I refer to your below email of 15 January 2021 regarding the Response to Submissions (RTS) for Modification Application (SSD-9063-Mod-1) and the Stage 2 – Detailed Design Application (SSD-10425) for the Tallawong Station Precinct South development. Submissions needed to be made to the Department by 1 February 2021. I apologise for the late submission but trust that Endeavour Energy's recommendations and comments will still be considered.

Endeavour Energy has noted the RTS Report for Stage 2 – Detailed Design Application (SSD-10425) includes 'Responses to organisation submissions, Endeavour Energy, Table 8: Key issues'. The responses provide in regard to the network capacity / connections issues and generally indicates they will comply with Endeavour Energy's network standards. However the following issues have been noted:

# MASSING COMPARISON

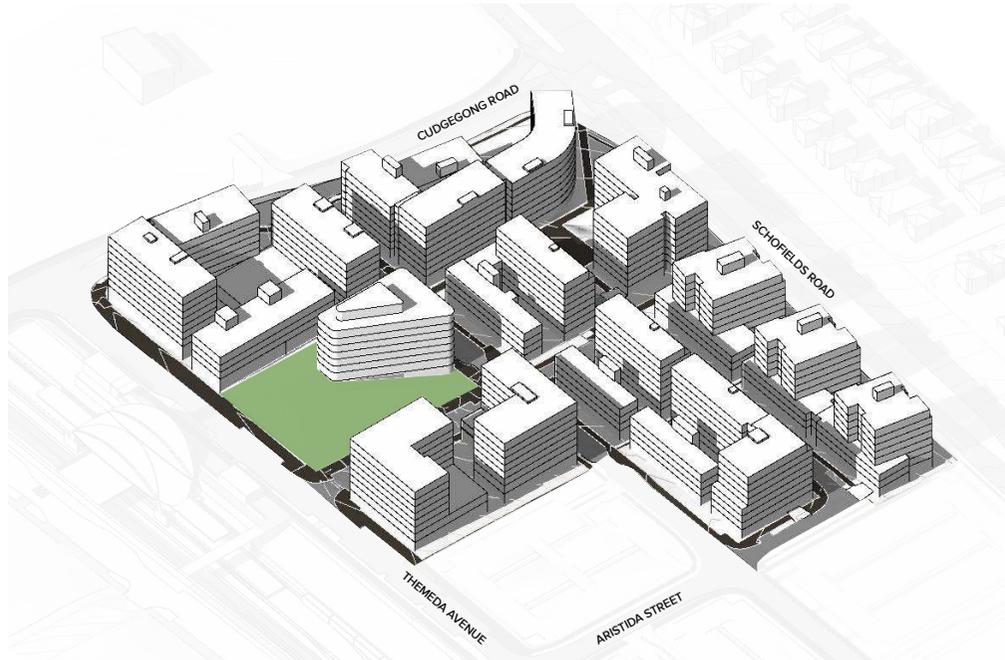
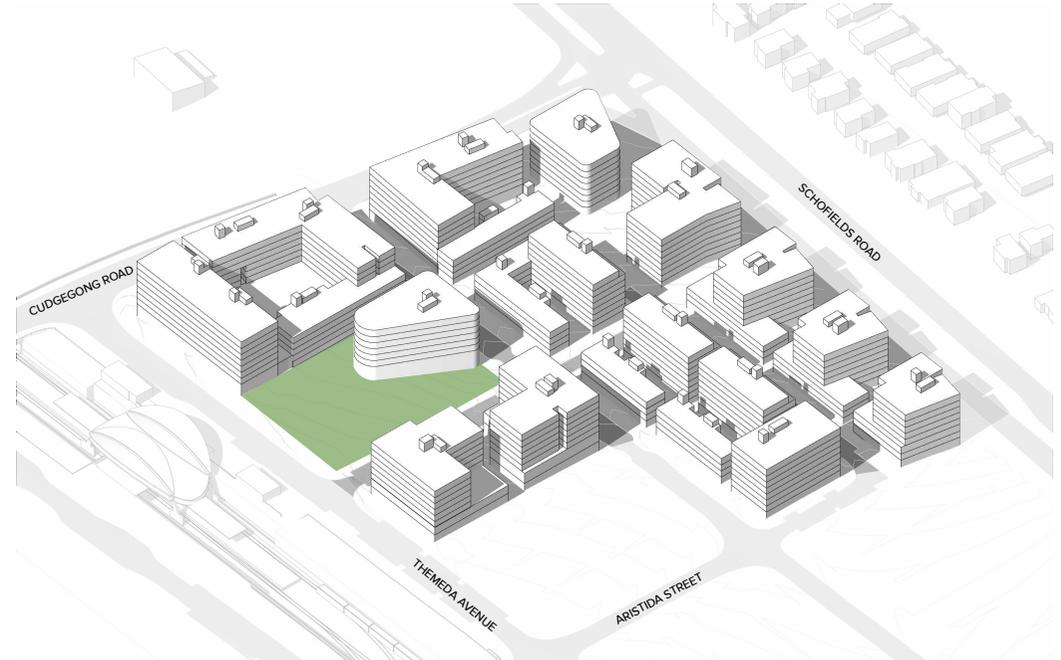
The response provided does not really address the issues raised by Endeavour Energy which have been raised on various occasions previously but continue to appear to be essentially ignored. From the Urban Design Report in the 'Massing Comparison' the amended proposal appears to increase the massing towards Cudgegong Road and Endeavour Energy's Rouse Hill Switching Station which does not appear to be addressed. Accordingly the recommendations and comments previously provided remain valid.
